ASSESSMENT REPORT

Gwandalan Residential Subdivision, Gwandalan 10_0205 MOD 3

STAGE 7
SITE PLAN

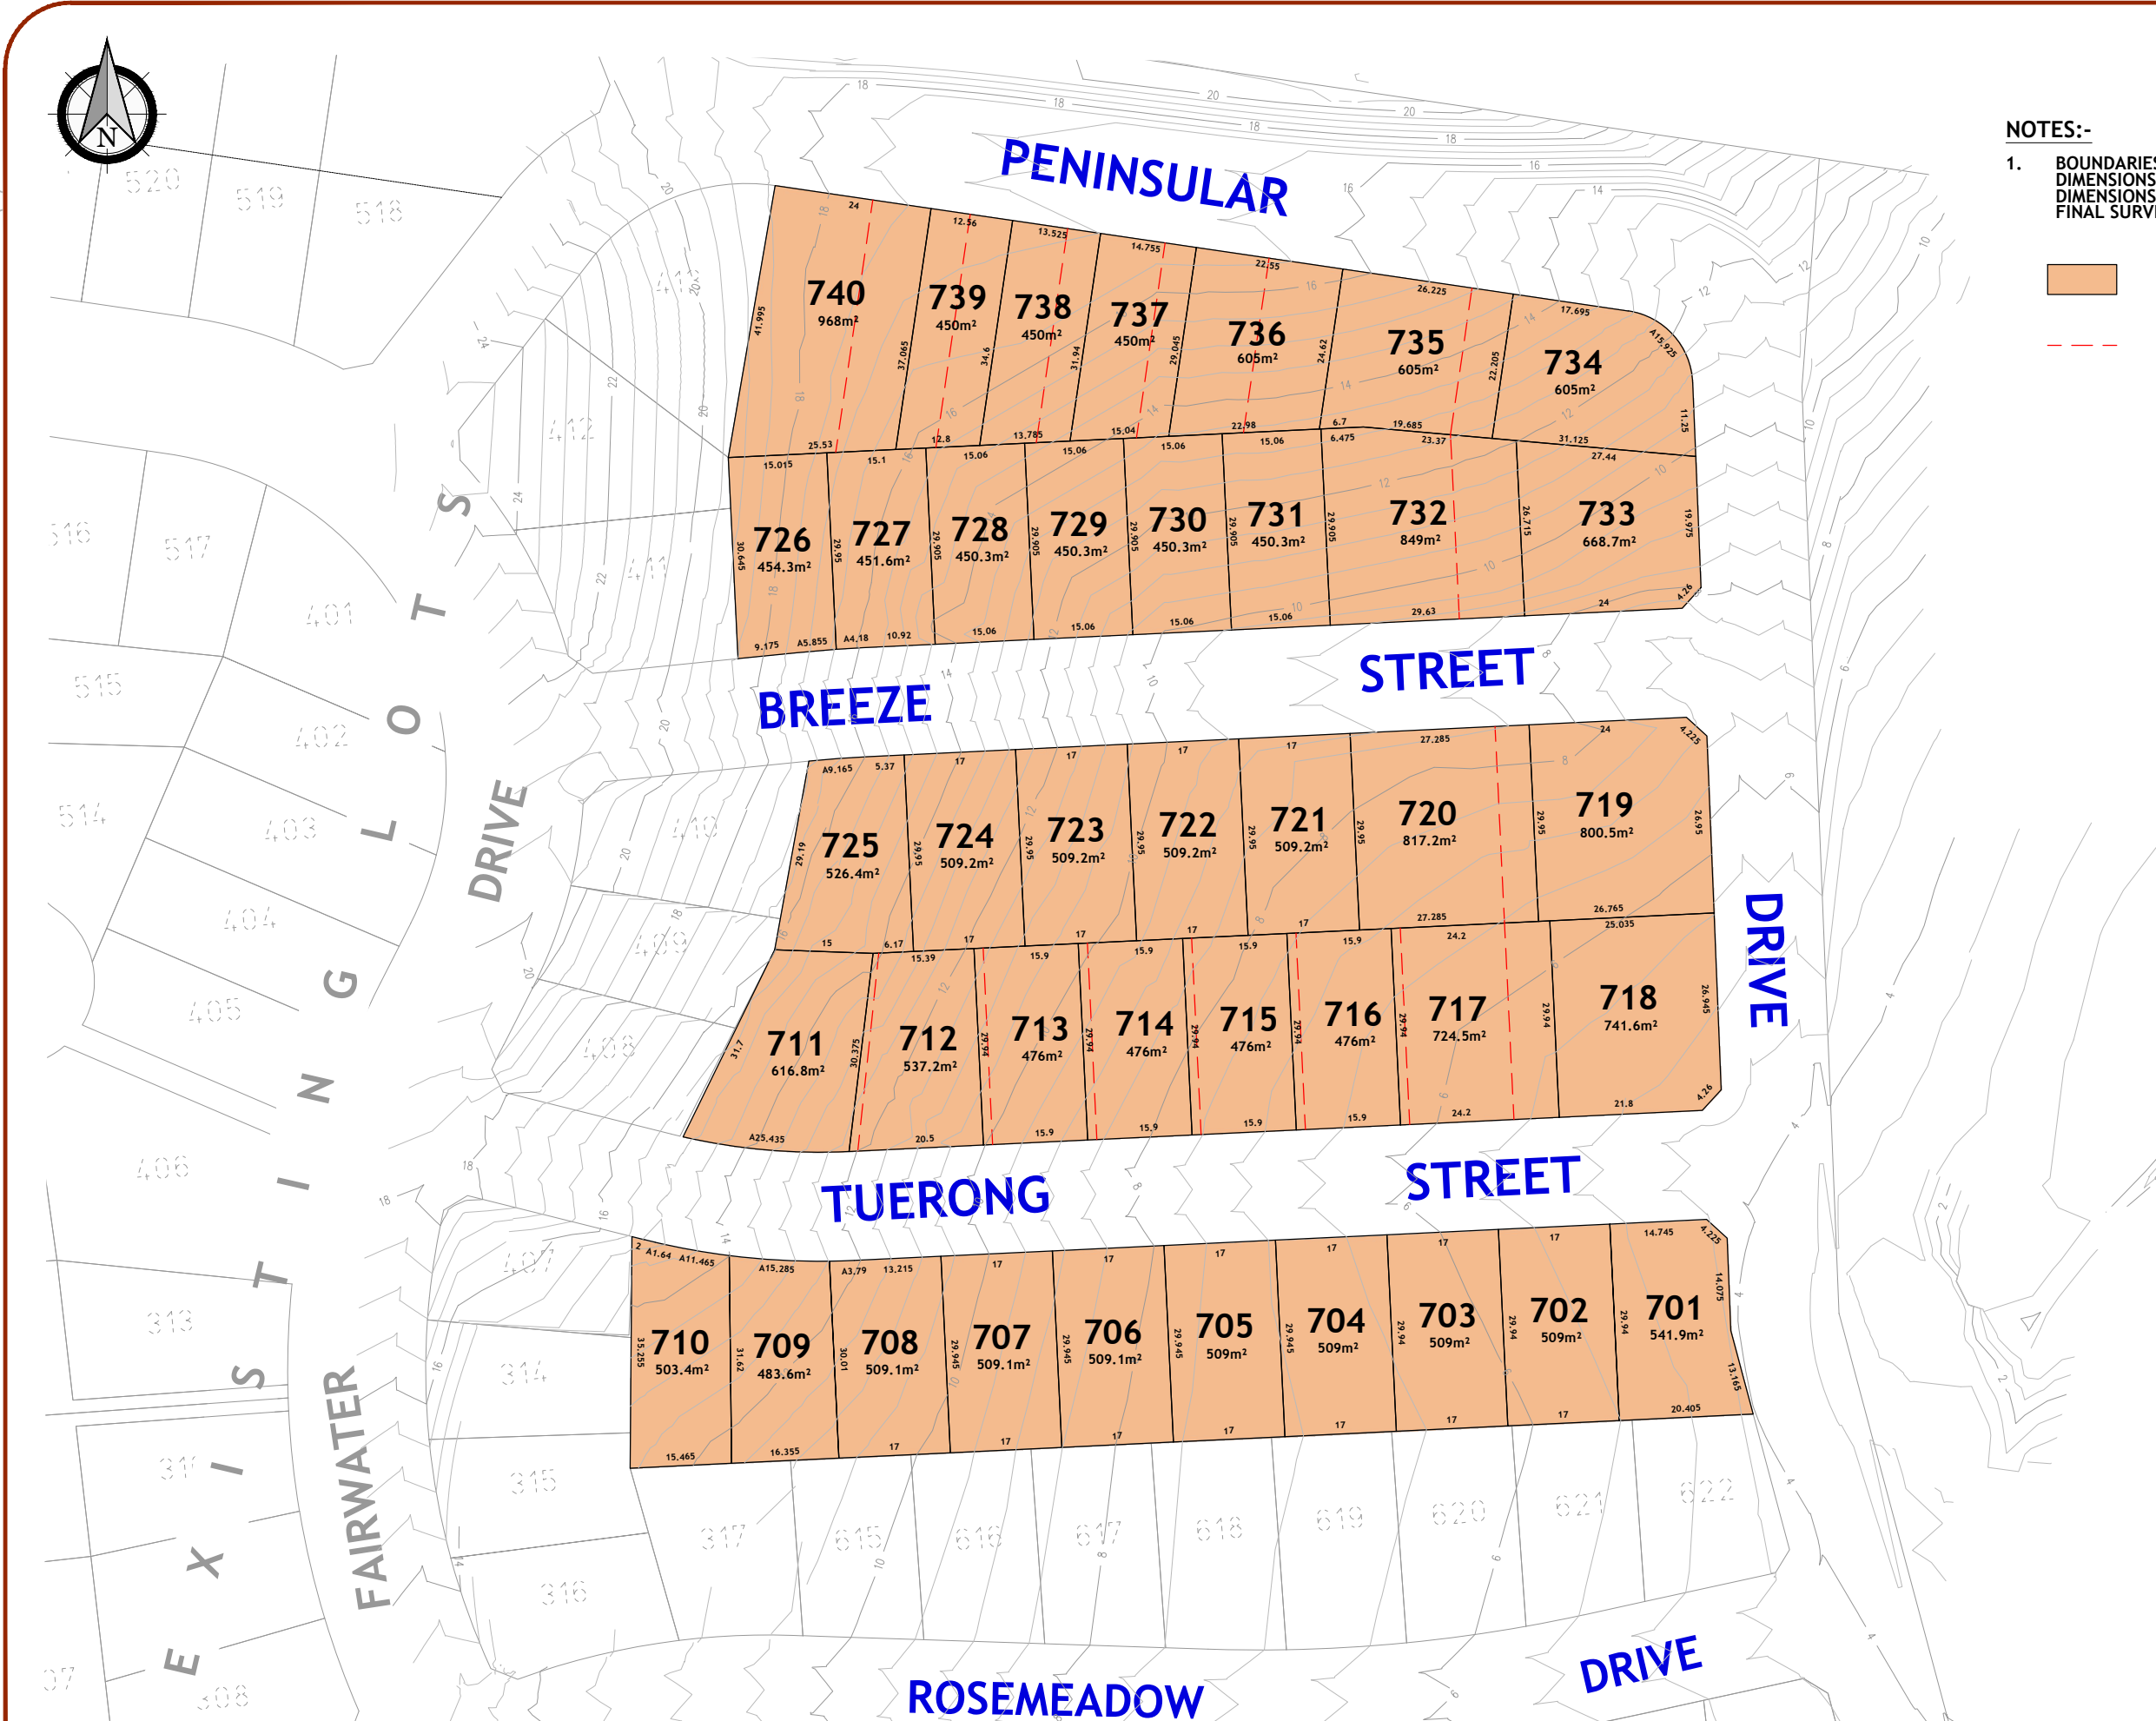
The first variation relates to minimum lot frontages at the building line which the Wyong DCP requires to be 15m. Reconfigured lots 737, 738 and 739 will not comply with this requirement as they will have reduced lot frontages down to a minimum width of 12.56m. The Department is satisfied with this minor variation as it relates to only three lots, will add variety to the subdivision and the lots can easily accommodate detached residential dwellings.

The second variation relates to corner lot areas which the Wyong DCP requires to be 700m². Reconfigured lots 733 and 734 will not comply with this requirement as they will have areas of 668.7m² and 605m² respectively. The Department is satisfied with this minor variation as it relates to only two lots and will provide corner lots with adequate areas to address dual frontage streetscape impacts, privacy issues, setback implications and intersection sight lines

Figure 5: Proposed Subdivision Staging Plan.

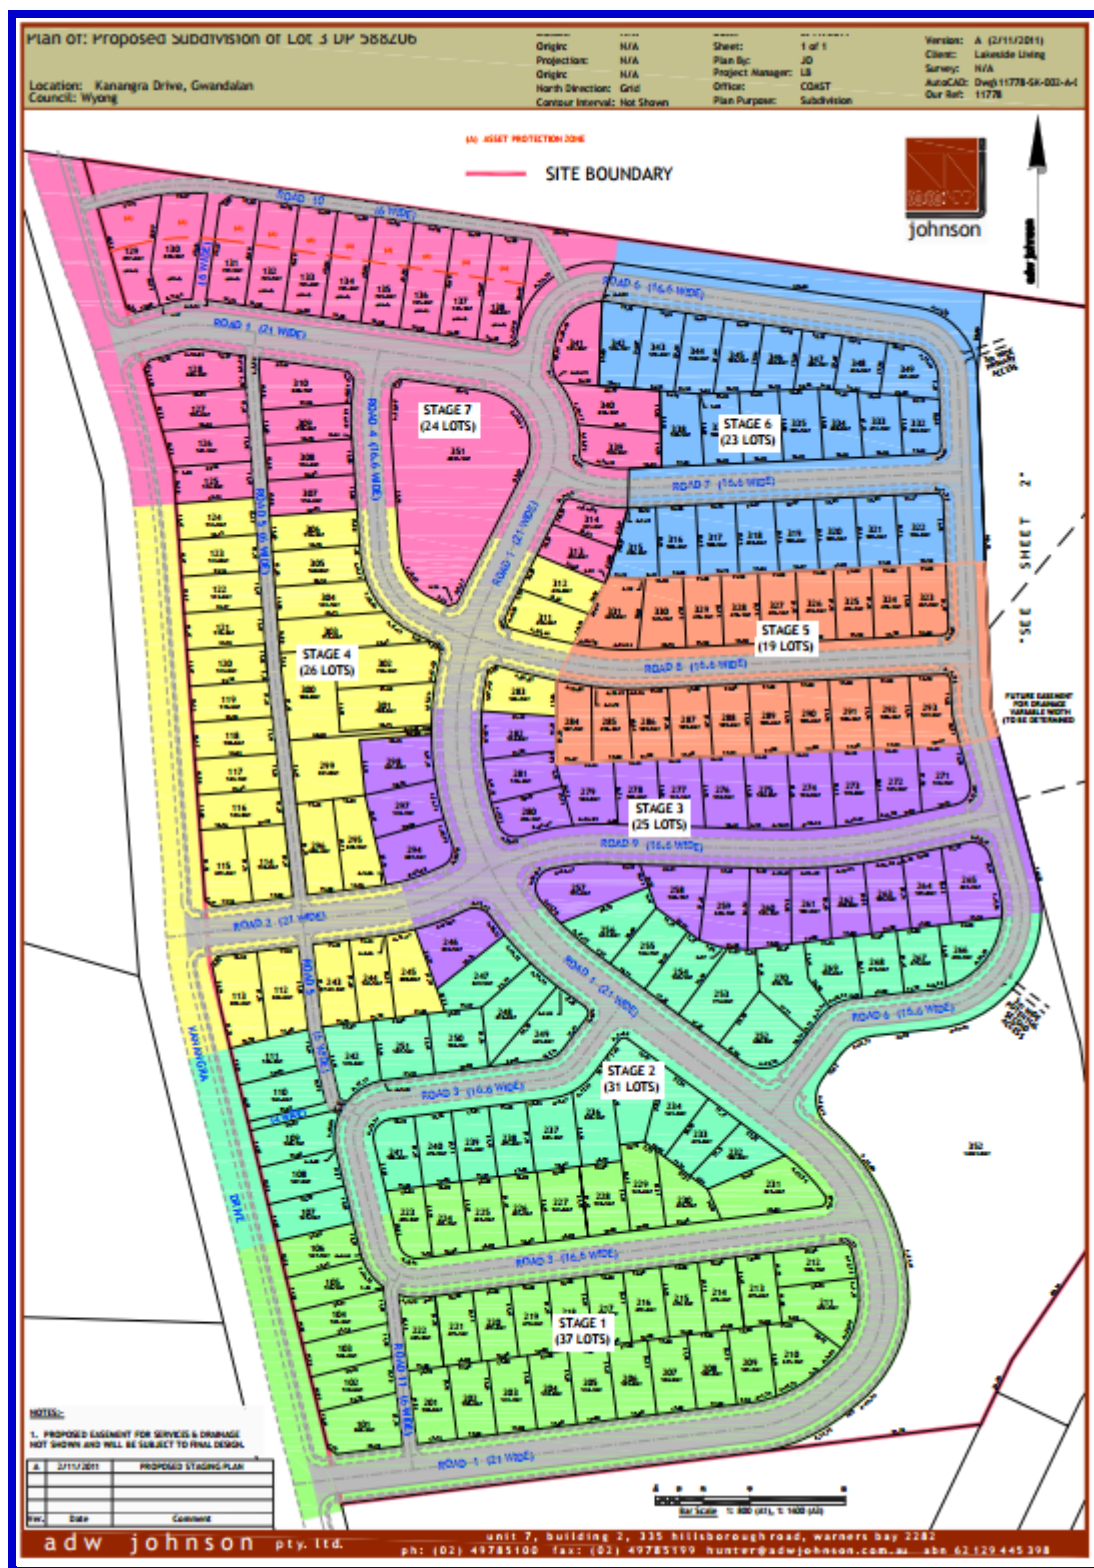
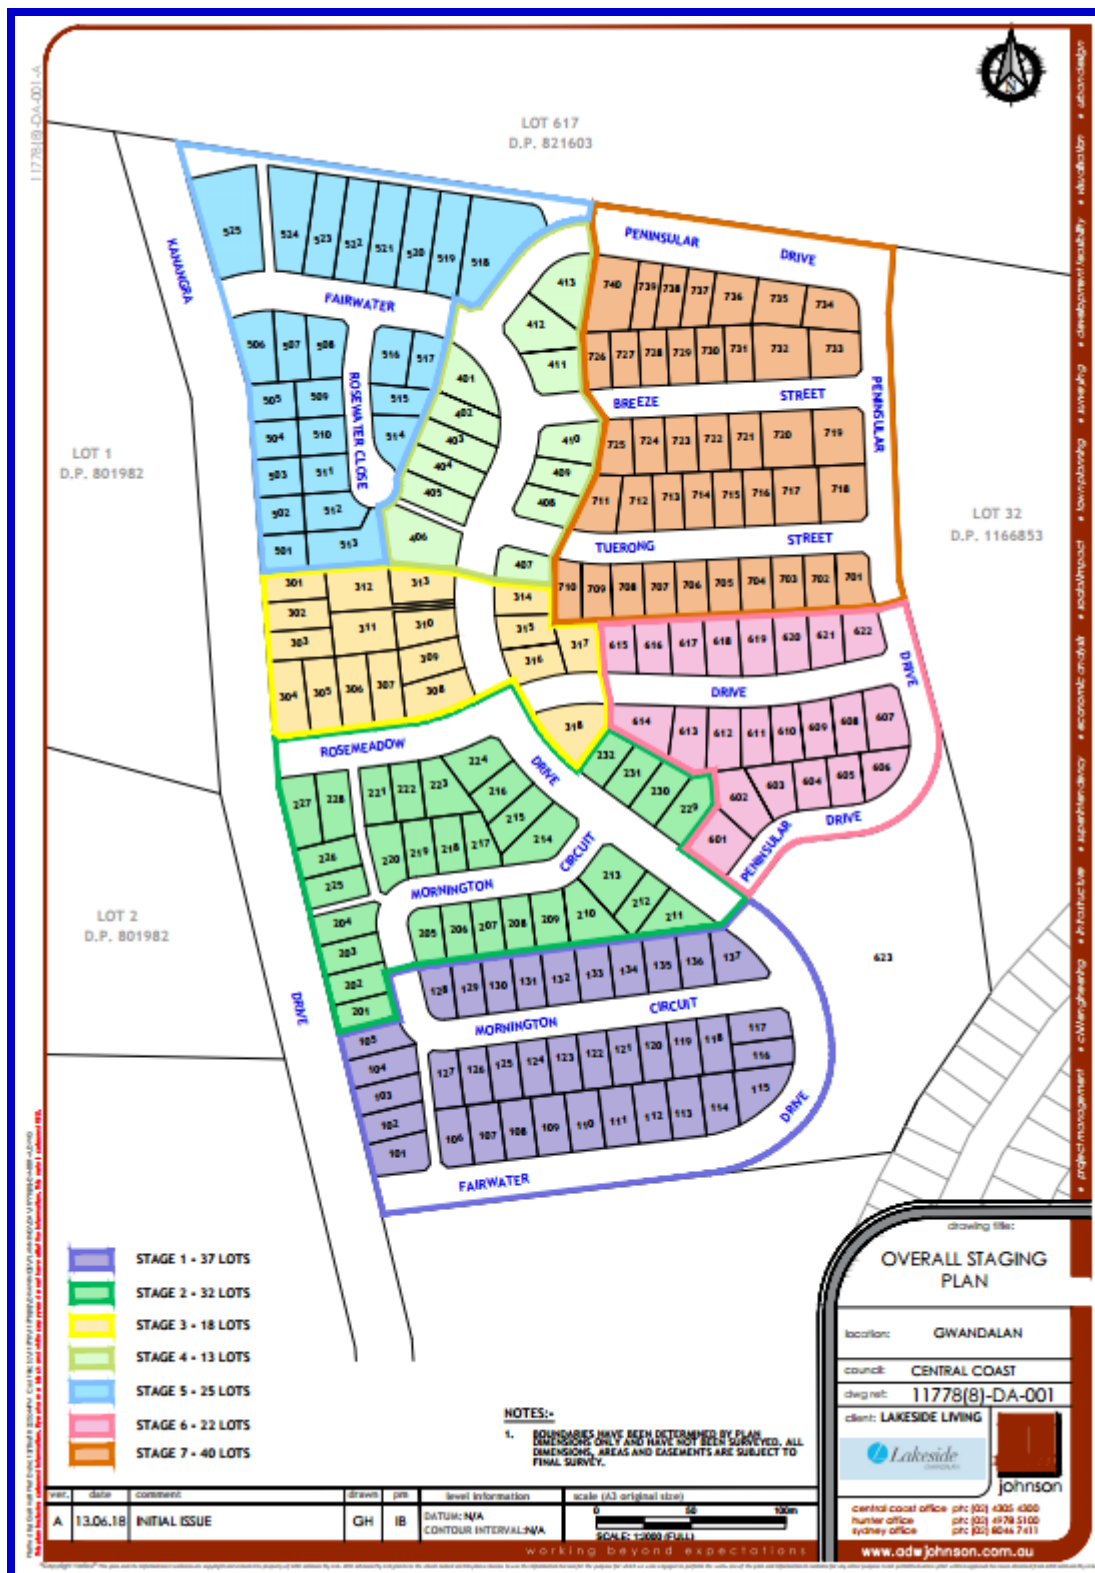
The application seeks approval for an updated subdivision staging plan (see **Figure 5**). The staging plan will maintain seven subdivision stages as currently approved but will reconfigure the sequencing of and boundaries between the stages. The modification is requested on the basis that the updated subdivision staging will reflect minor boundary changes approved by Central Coast Council as part of the construction certificate process.

The updated subdivision staging plan is inconsistent with the original subdivision staging plan for the site provided by the Gwandalan Development Control Plan (Gwandalan DCP) as part of 10_0205 (see **Figure 3**). Notwithstanding this inconsistency, the Department considers the updated subdivision staging plan to be acceptable. The Gwandalan DCP's subdivision staging plan has previously been varied by 10_0205 MOD 1 (see **Figure 4**). Furthermore, the subdivision is at an advanced stage of development with most of the subdivision stages either complete or nearing completion as of July 2018 (see **Figure 7**).

The remaining stage to be developed under the updated subdivision staging plan (stage 7) corresponds with the last stage to be developed on the site. On this basis, the Department is satisfied that the changes to the staging plan are minor and acceptable.

Figure 6: Reconfigured Subdivision Lot Layout.

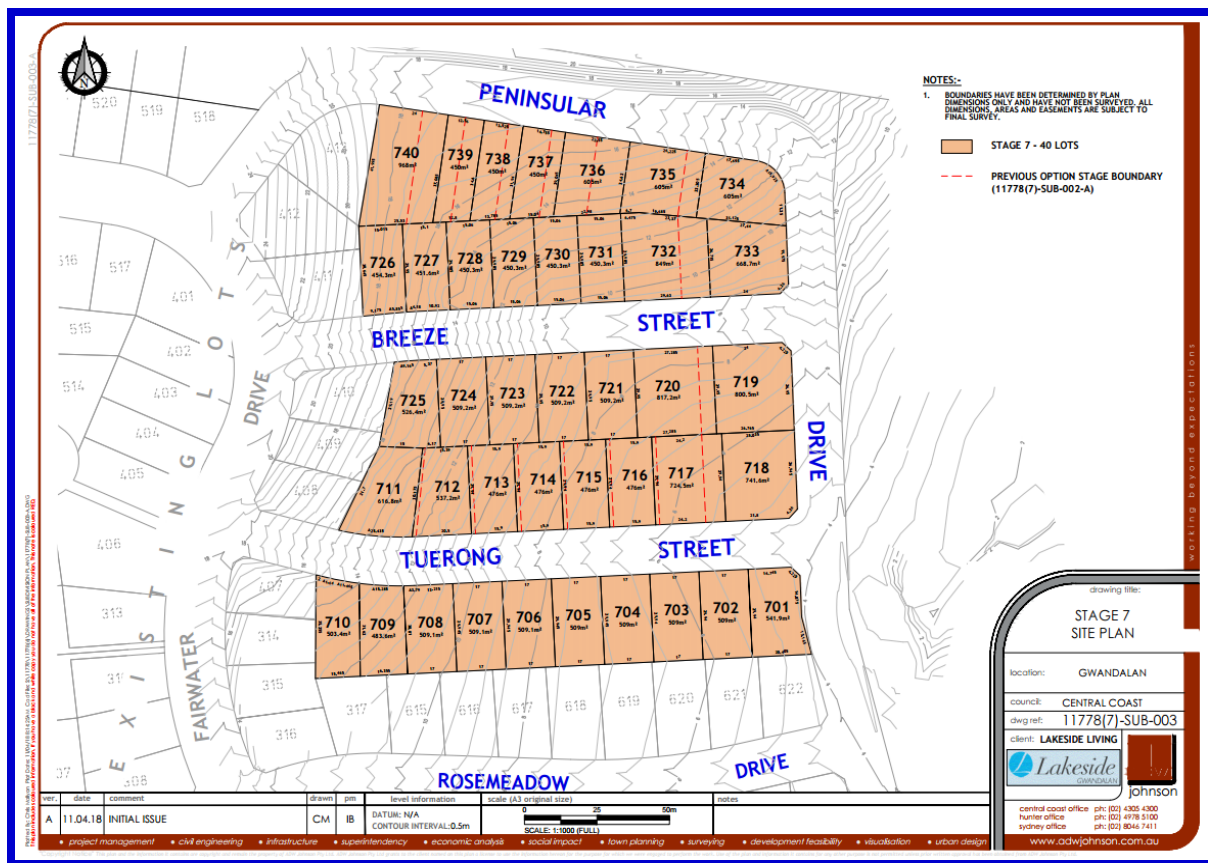
The Department supports the reconfigured subdivision layout as all the reconfigured lots will comply with the 450m² minimum lot size development standard that applies to the site under the Wyong Local Environmental Plan 2013.

The Department notes the reconfigured subdivision layout is not fully compliant with the Wyong DCP.

On this basis, the Department is satisfied that the reconfigured subdivision lot layout is acceptable as it will still result in appropriately sized and dimensioned residential lots that will be suitable for future residential housing.
